## **DEPARTMENT OF PUBLIC WORKS**

### **MEMORANDUM**

SUBJECT: SX-22-00011 Dixon

**Public Works has reviewed the Shoreline Exemption application. Please see comments below:**

DENNIS DIXON
 SITE PLAN

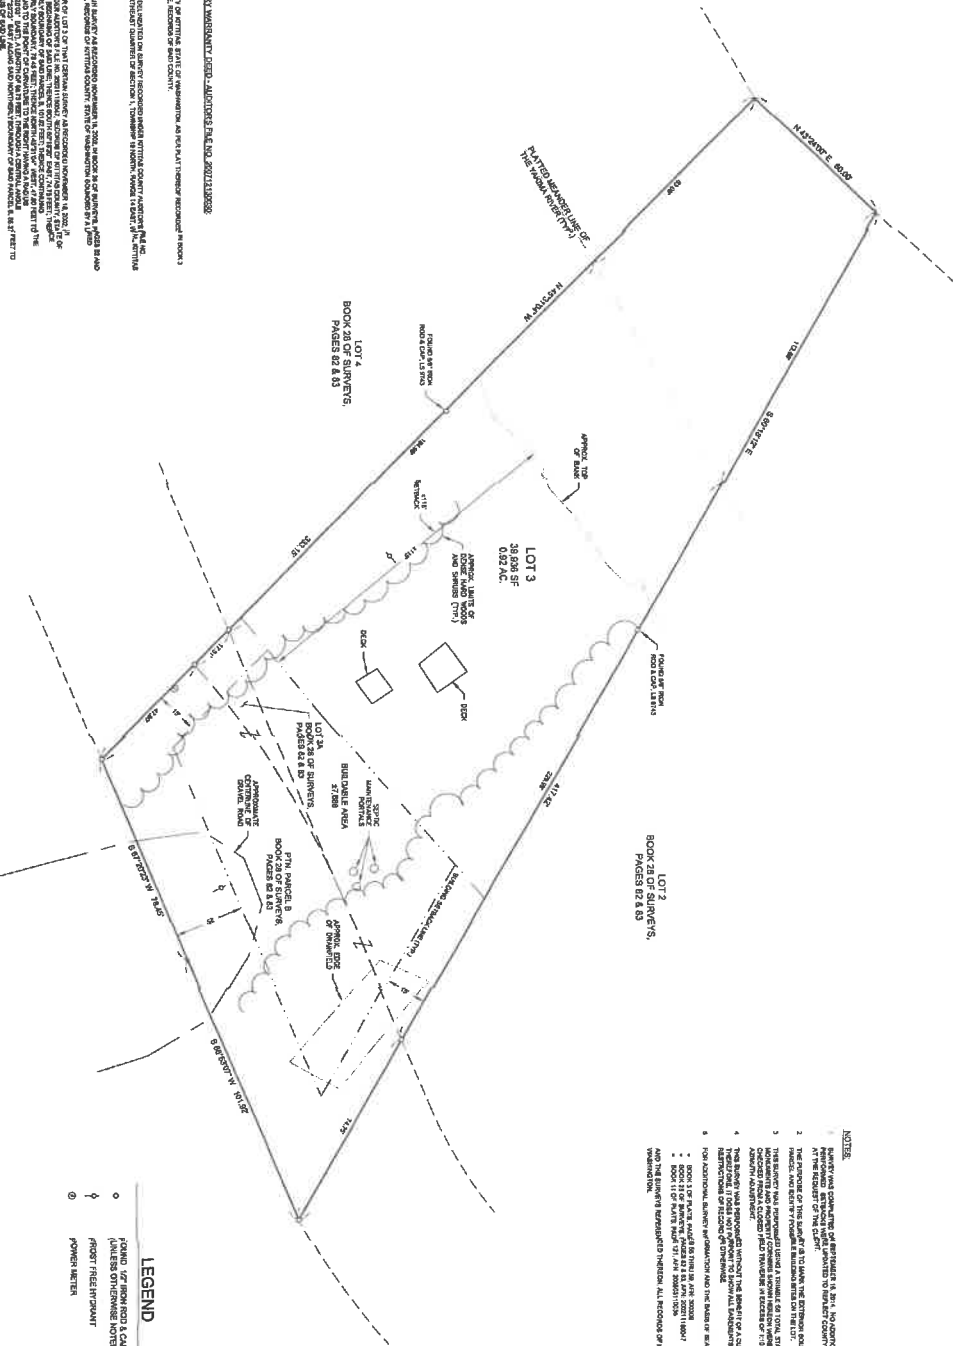
The parcel contains FEMA designated Floodway. Per the submitted site plan, the proposed single-family residence is located outside the Floodway. Please be advised that the Floodway is highly restricted and any development within the floodway must be permitted through a floodplain development permit and must demonstrate no rise of 100-year flood elevations before being permitted. No new or substantially improved residences are allowed within the Floodway.
